Transport Engineering

REF: N168210

DATE: 18 December 2020

RE: 338 PITT STREET, SYDNEY – RESPONSE TO STAKEHOLDER SUBMISSIONS

Figure 4: Proposed Ground Floor Plan

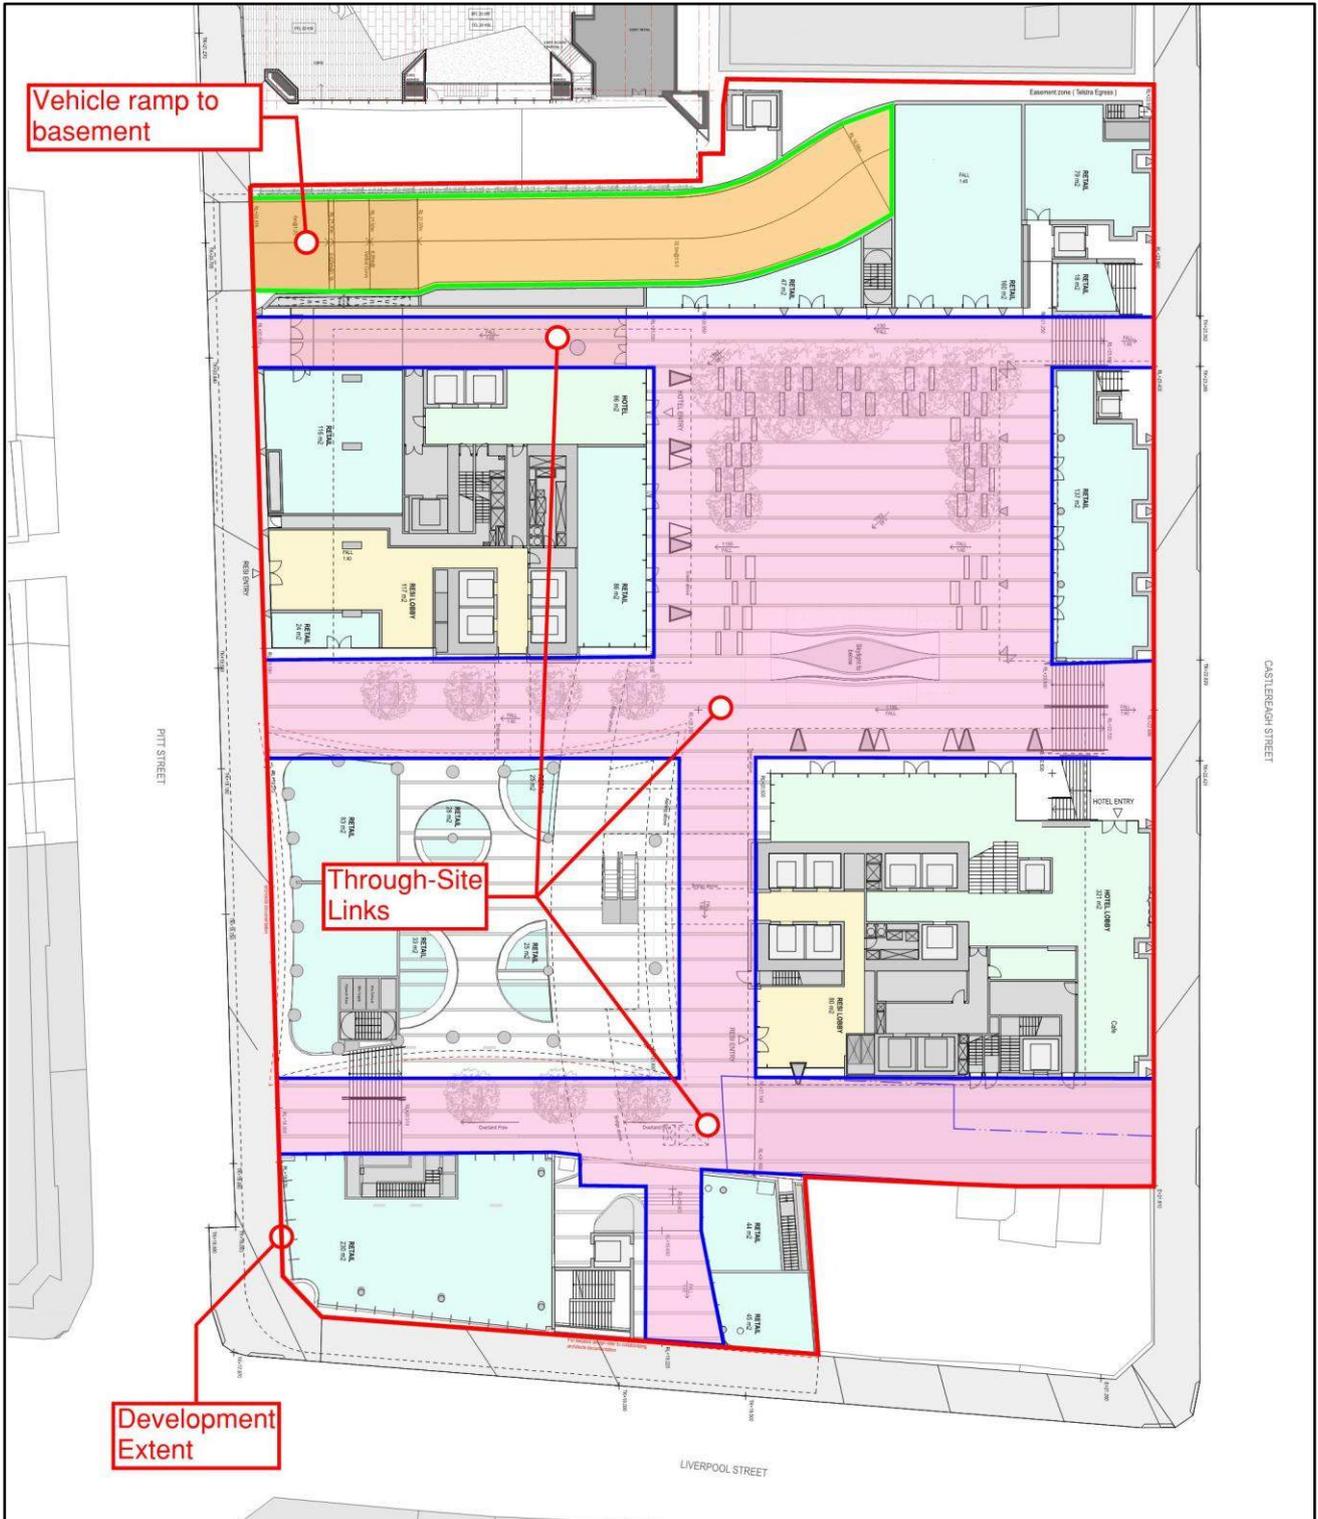
21. The driveway crossover should be reduced in width – its current width will adversely impact the safe and efficient passage of pedestrians on Pitt Street. The crossover is to be reduced in size having regard to Section 3.11.11 of the Sydney DCP 2012.

The development proposes to consolidate all vehicular access into the basement via a single access driveway on Pitt Street in the north-west corner of the site. This would realise the removal of five existing driveways from the site frontages and construction of one. Provision of a single driveway crossover to accommodate all site generated traffic would represent a significant improvement over existing conditions and certainly better than a proposal that may include more than one crossover. This improves the public domain and pedestrian amenity generally.

Given Pitt Street is also one-way northbound, all vehicles would turn right on entry and right on exit. This results in the crossover of vehicles when entering and exiting. While this is not ideal, it is also not uncommon in CBD locations where there are a greater proportion of one-way streets. Such access arrangements result in the need to facilitate trucks and cars in the same access, with sufficient width to allow the passing of entering and exiting vehicles at the access point.

GTA prepared vehicle swept paths as part of the submission. This included 8.8-metre long MRVs, with updated swept paths included in Attachment 1. As shown, the driveway currently provides for two vehicles to appropriately pass however is not recommended to reduce the driveway crossover width any further than that documented.

title
General Arrangement Plans
Basement 4 - Residential Parking

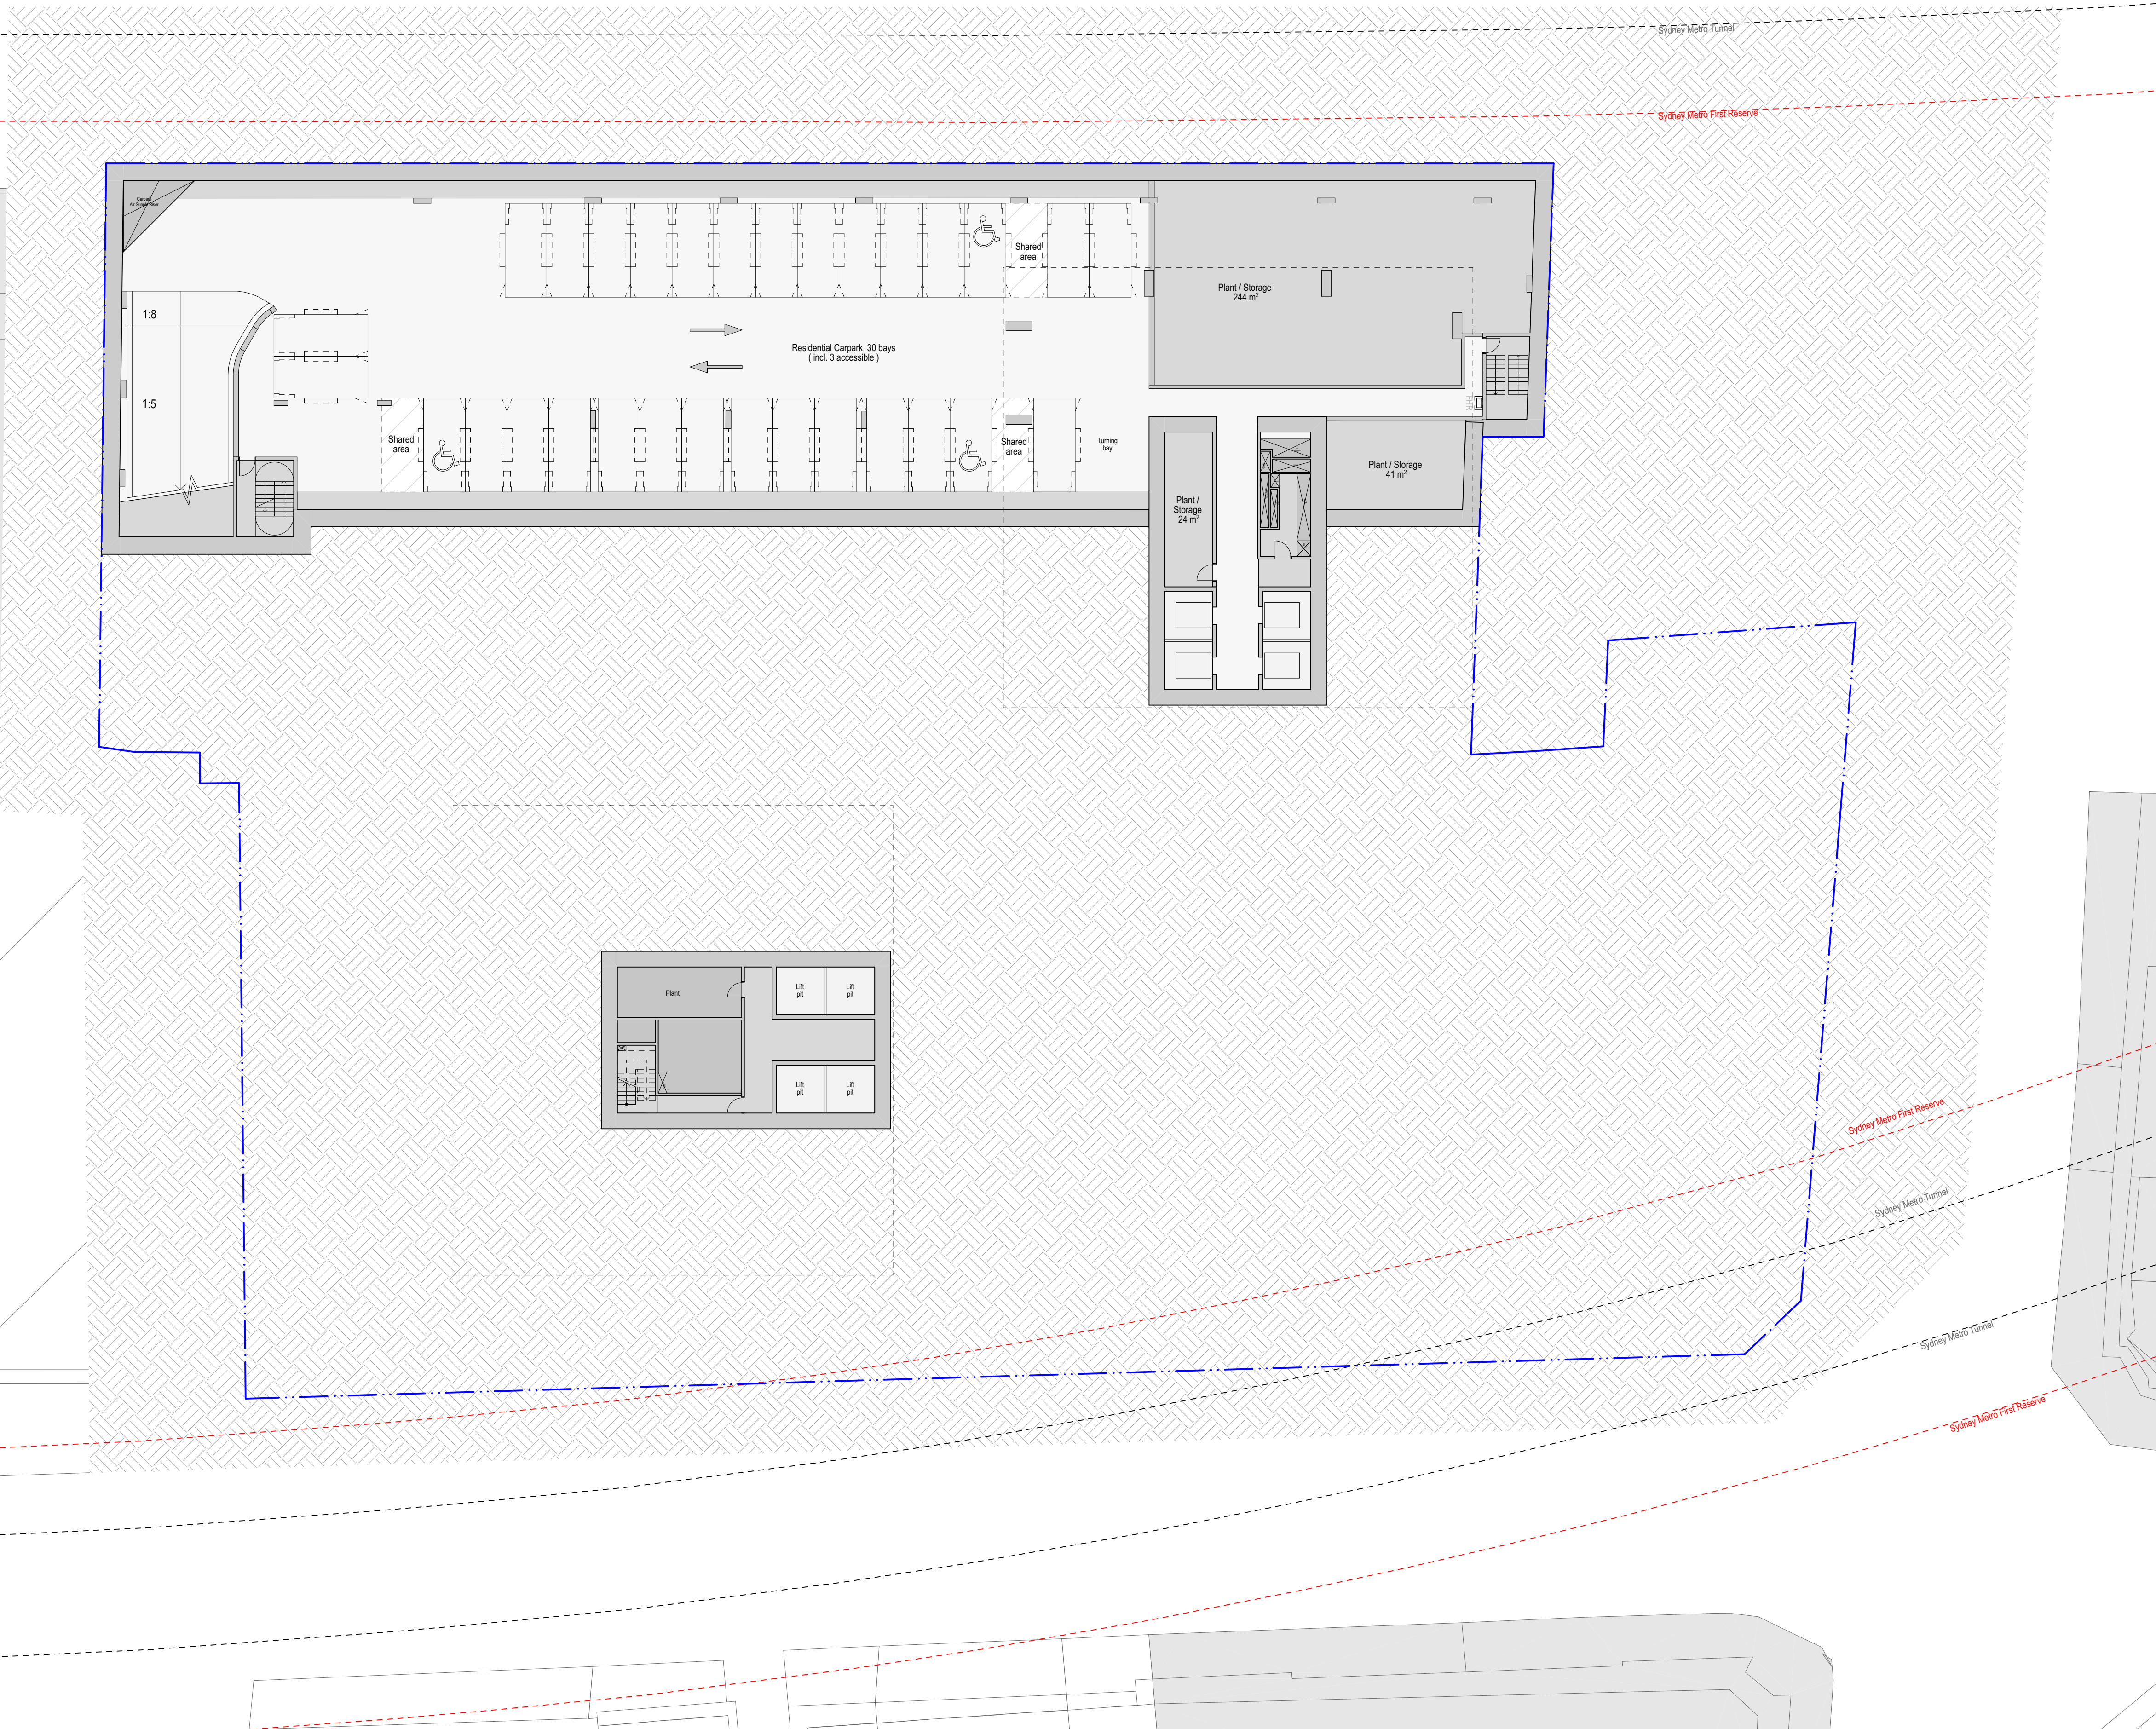
19. Providing car parking spaces for people with disability in accordance with the City's controls is a high priority. It is recommended that the development is amended to provide 89 accessible car spaces for residents (one car space for every adaptable unit) and accessible visitor spaces in accordance with Schedule 7.8.5 of the Sydney DCP 2012.

As part of the response to submissions process, the basement plans have been refined to include one accessible car space for every adaptable apartment (a total of 89 residential accessible spaces). The site is in Category A area and as per Clause 7.5 (2) of the Sydney Local Environmental Plan 2012, visitor parking is not required. As such no visitor parking, either standard or accessible, is included in the proposed development.
